August 15, 2022

Re: Oxbow and Coors Pavilion Developments Traffic Impact Study

Margaret Haynes, P.E.  
Assistant Traffic Engineer  
New Mexico Department of Transportation District Three

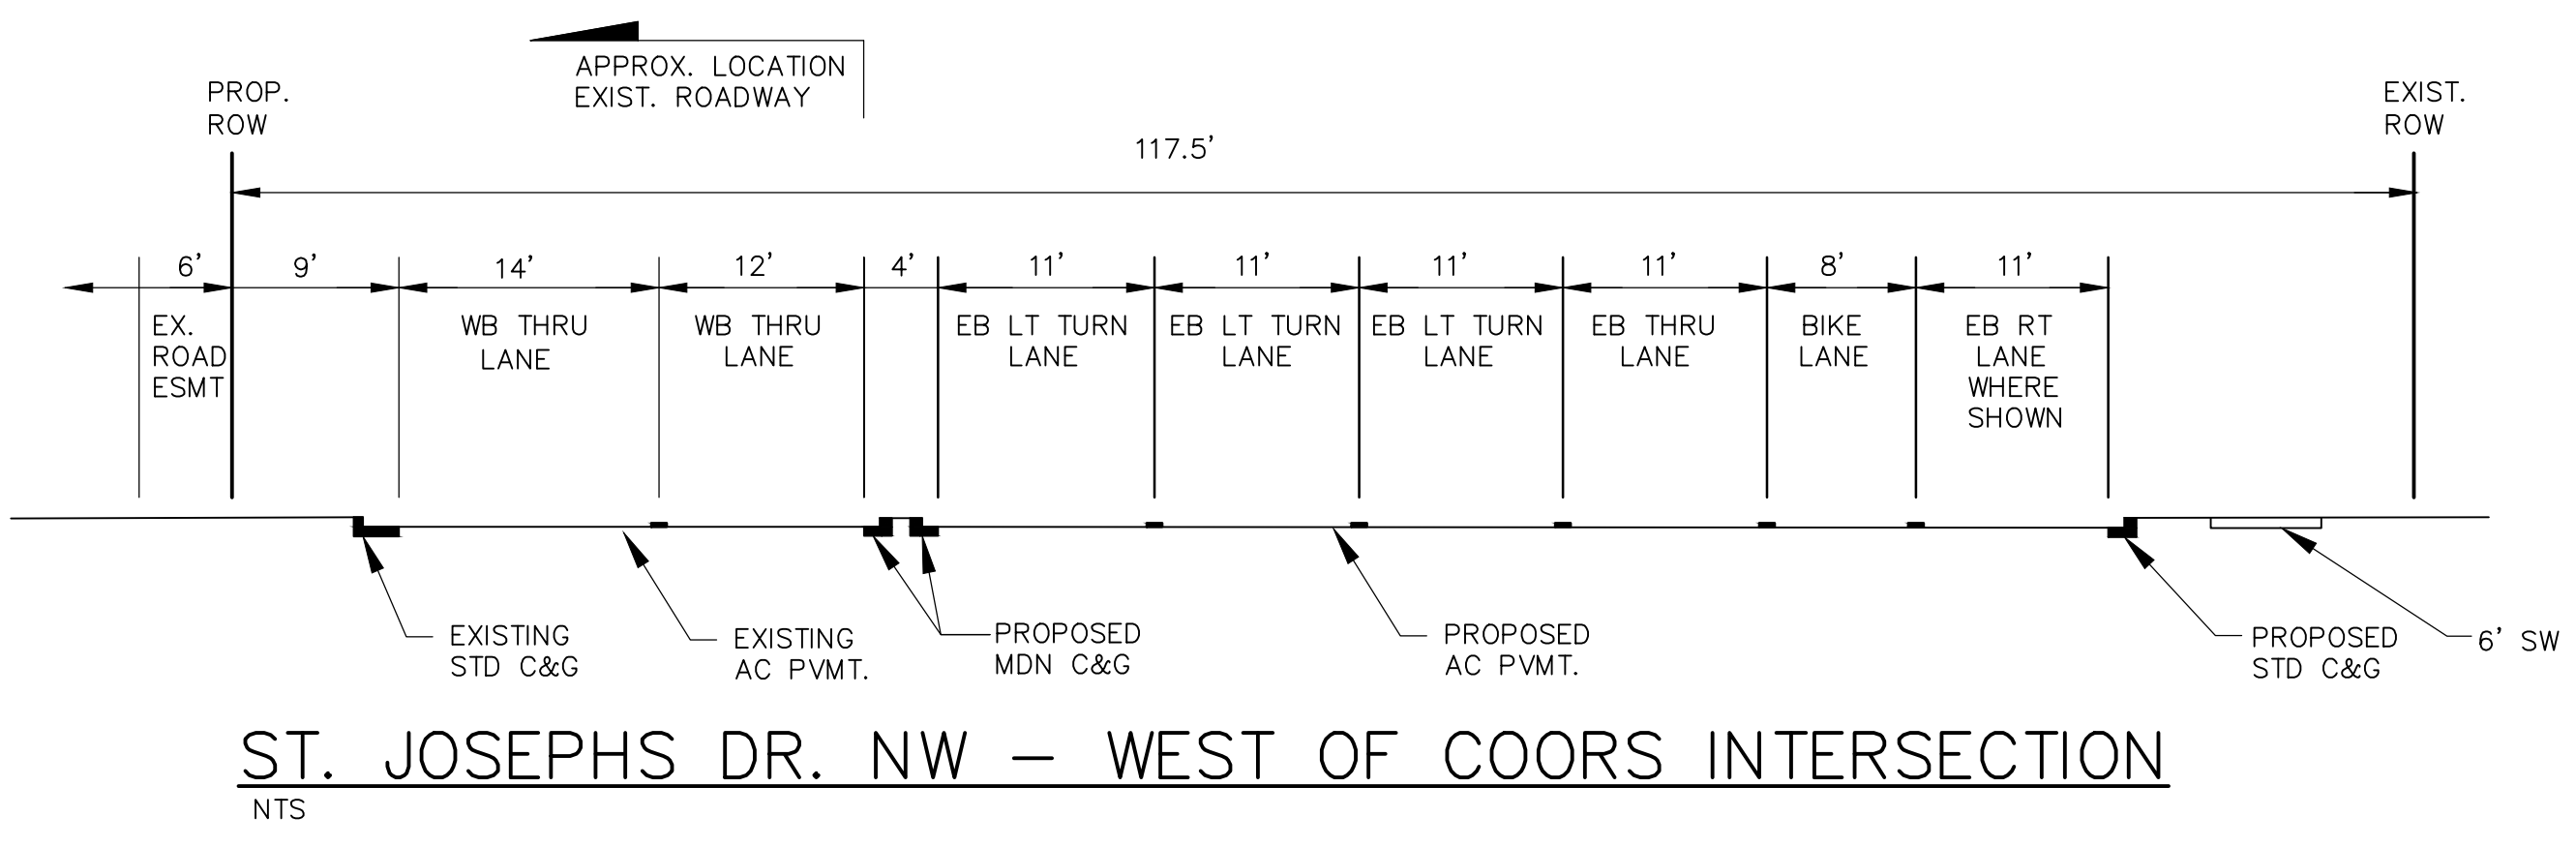
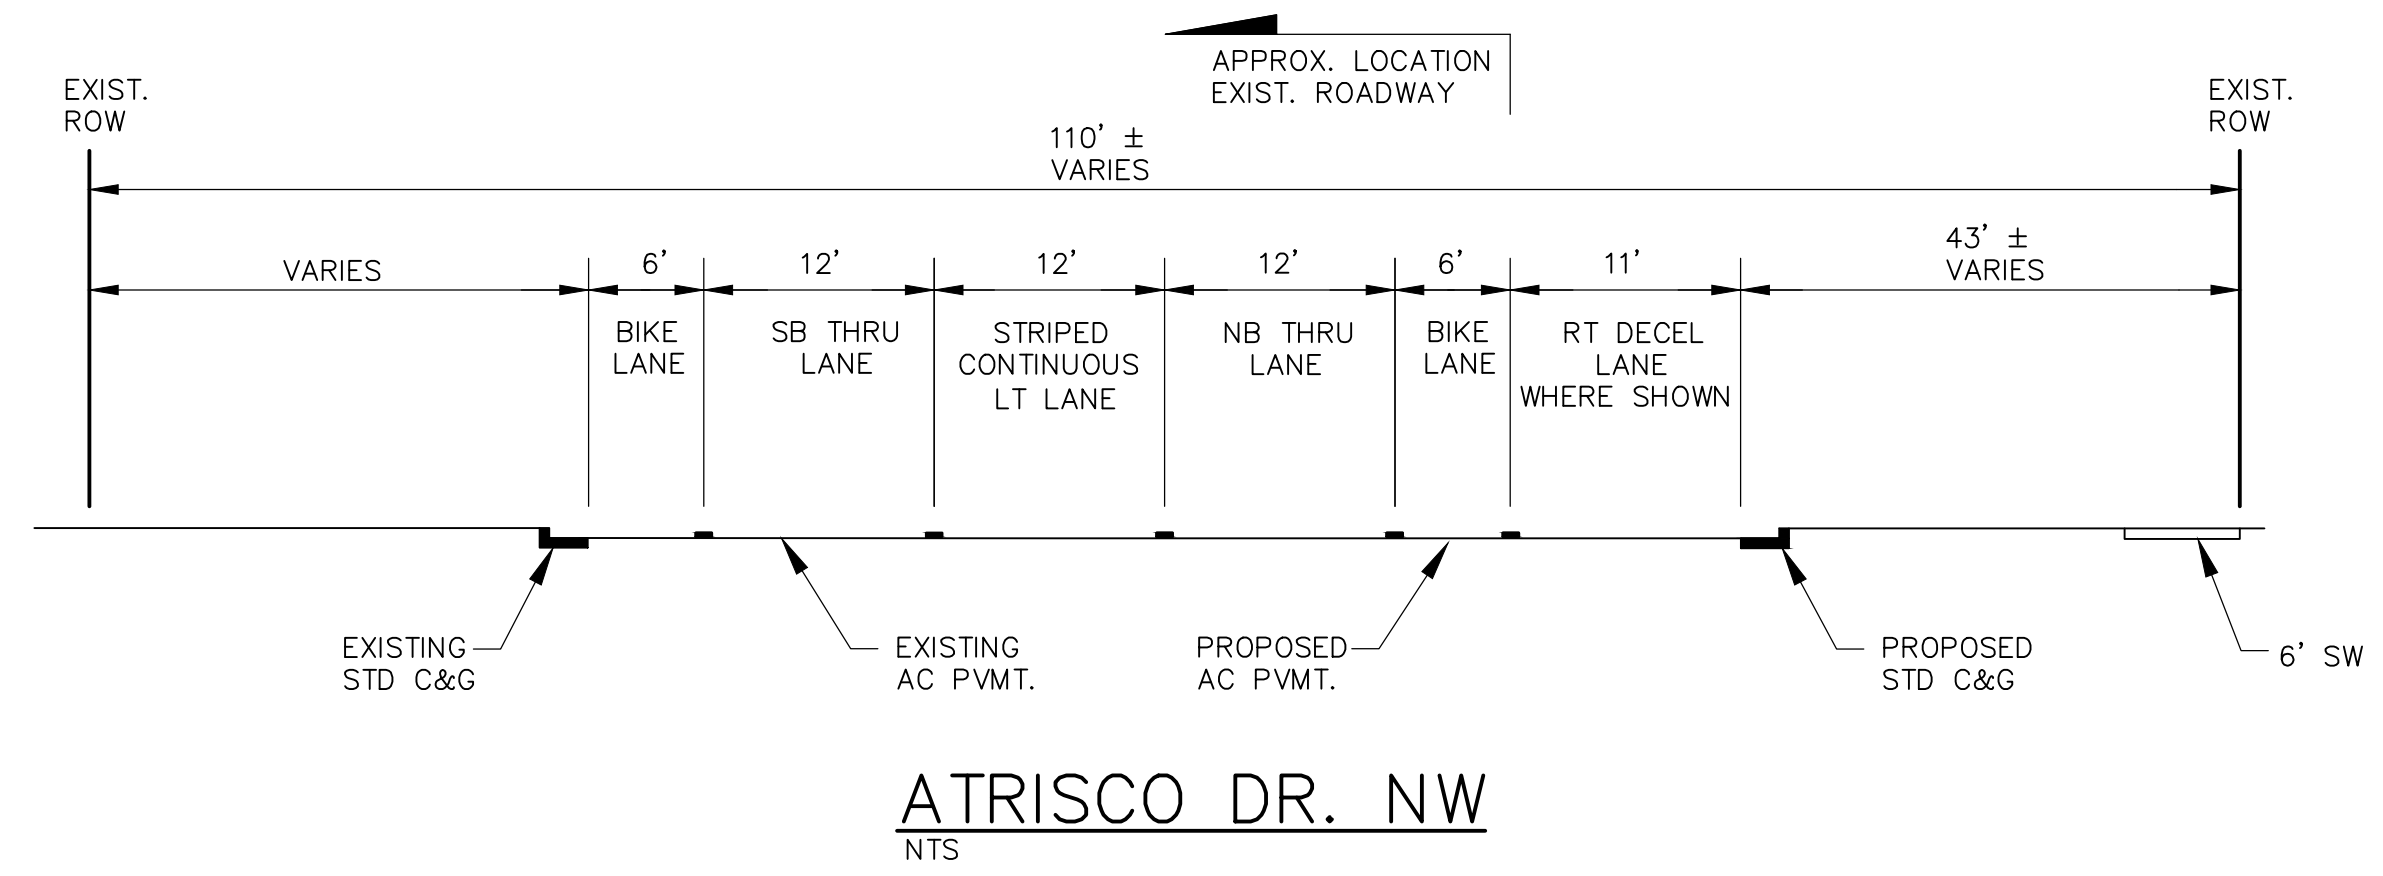
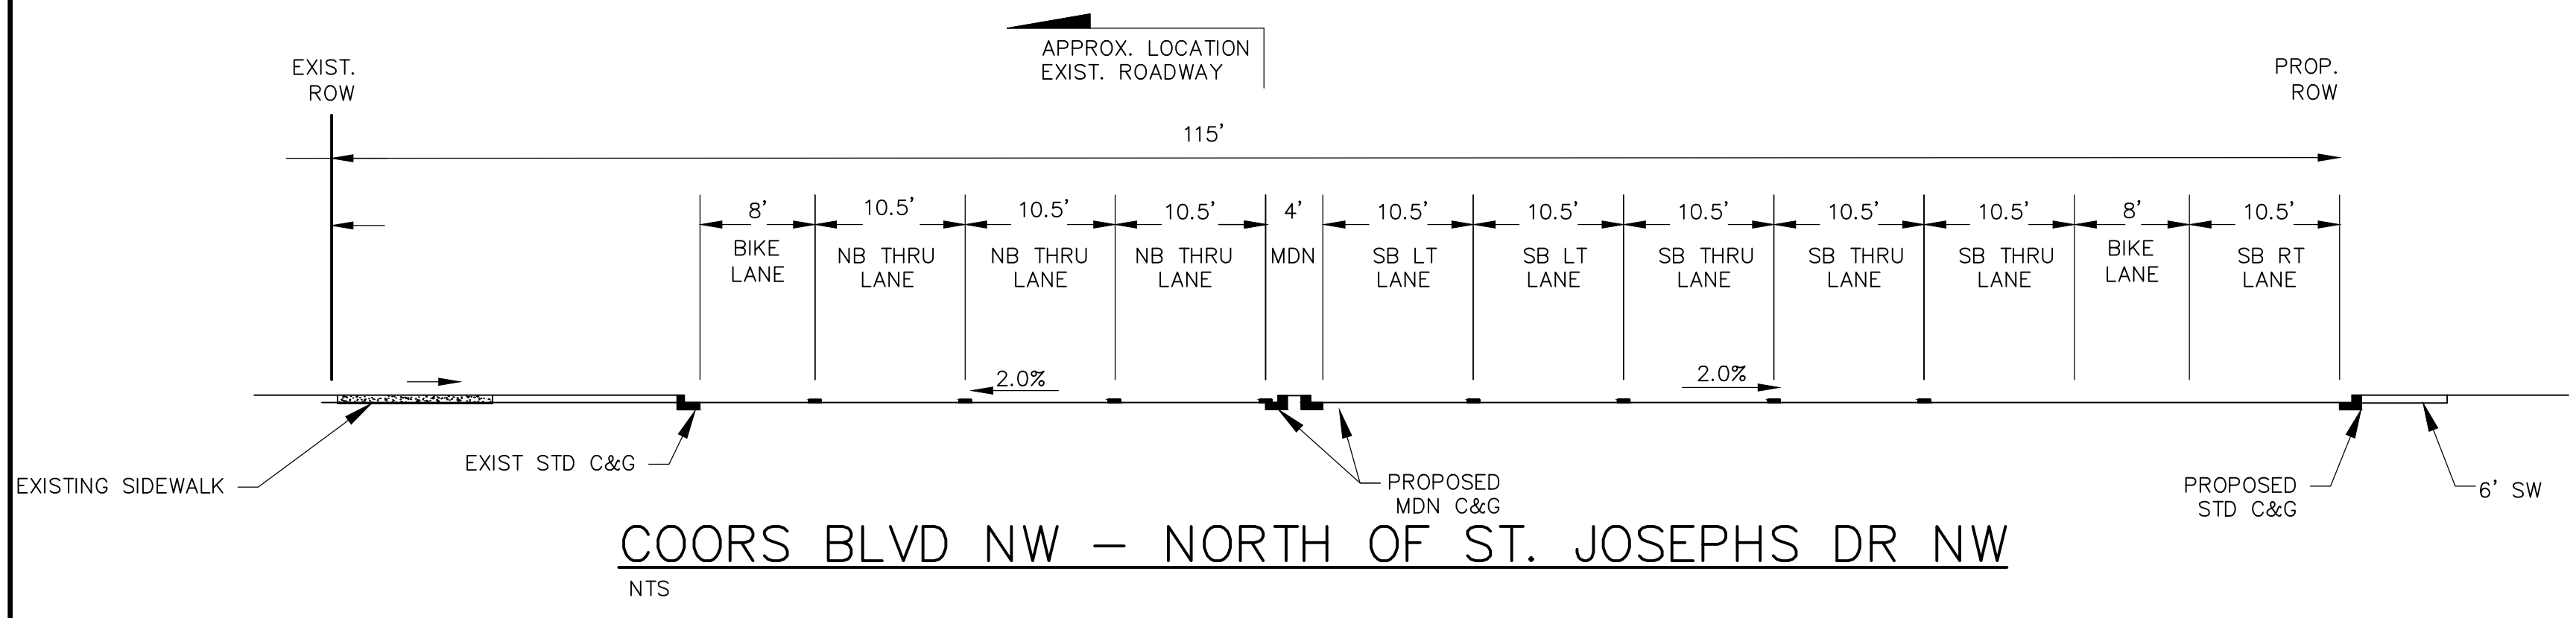
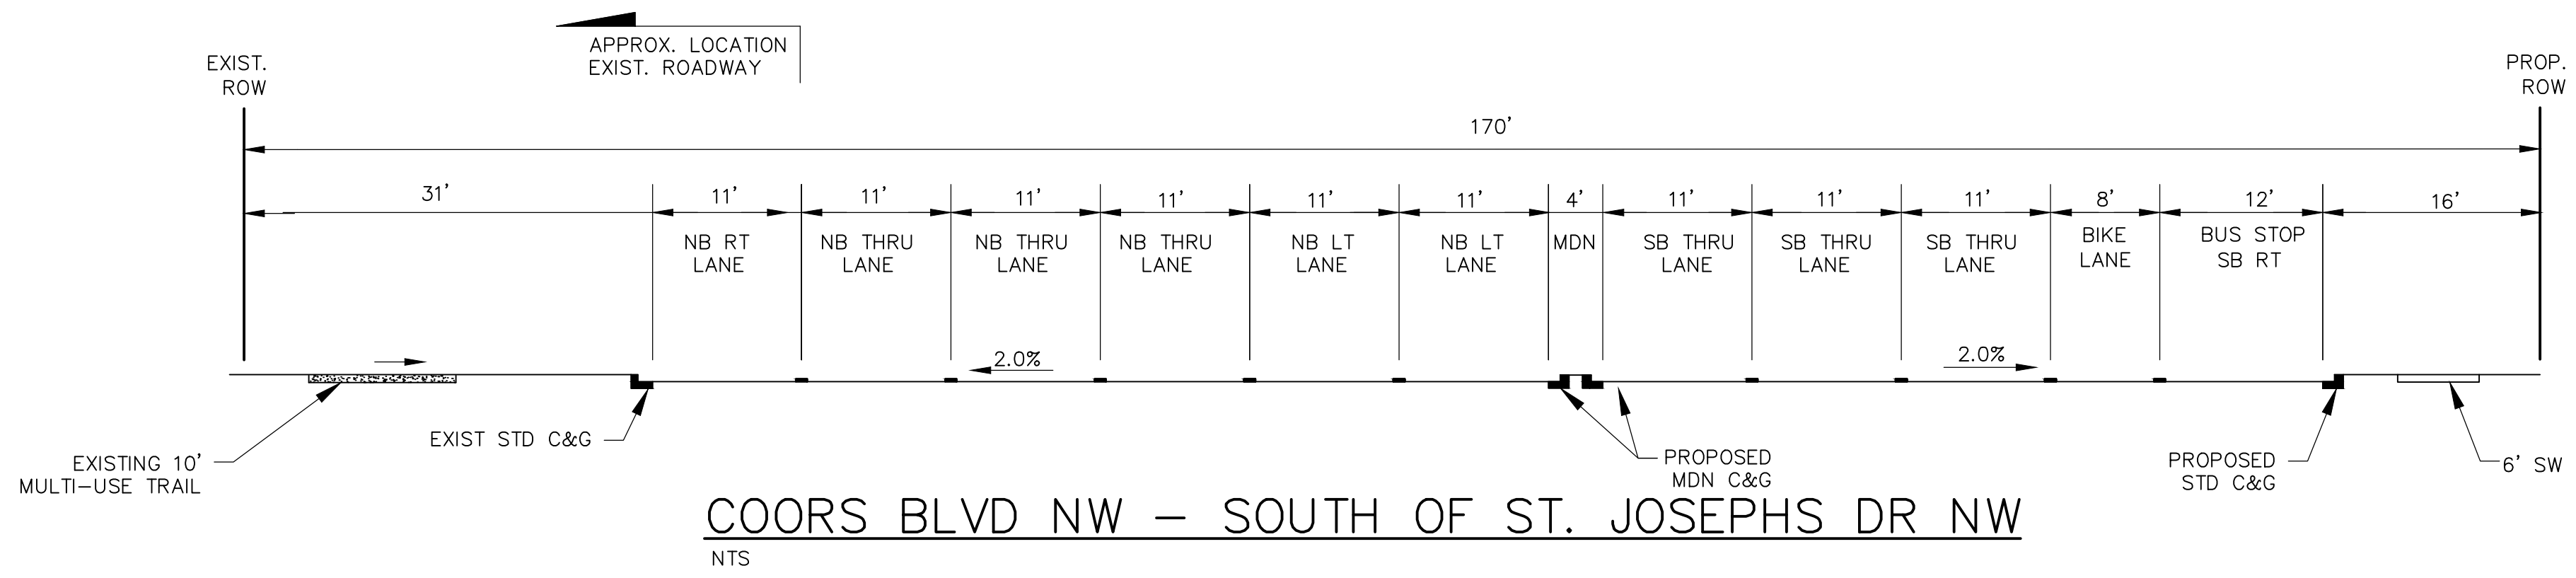
1. The proposed geometry used to develop the triple eastbound lefts for on St. Joseph's Drive at NM 45 should meet the SAMM redirect taper requirements.

2. All widening on NM 45 shall be from its centerline. The proposed geometry used to develop the dual northbound and southbound lefts on NM 45 at St. Joseph's Drive shall meet the SAMM redirect taper requirements.

4. The lane widths for northbound and southbound through lanes shall remain twelve (12) feet.
5. The divided median island width on NM 45 shall be a minimum six (6) feet in width.

6. The proposed triple left turns shall be designed to contain design vehicle WB-40 with two passenger cars with no over tracking in adjacent lanes.
7. NMDOT has concerns regarding signal timing operations for pedestrians with the proposed triple right eastbound left turn configuration.
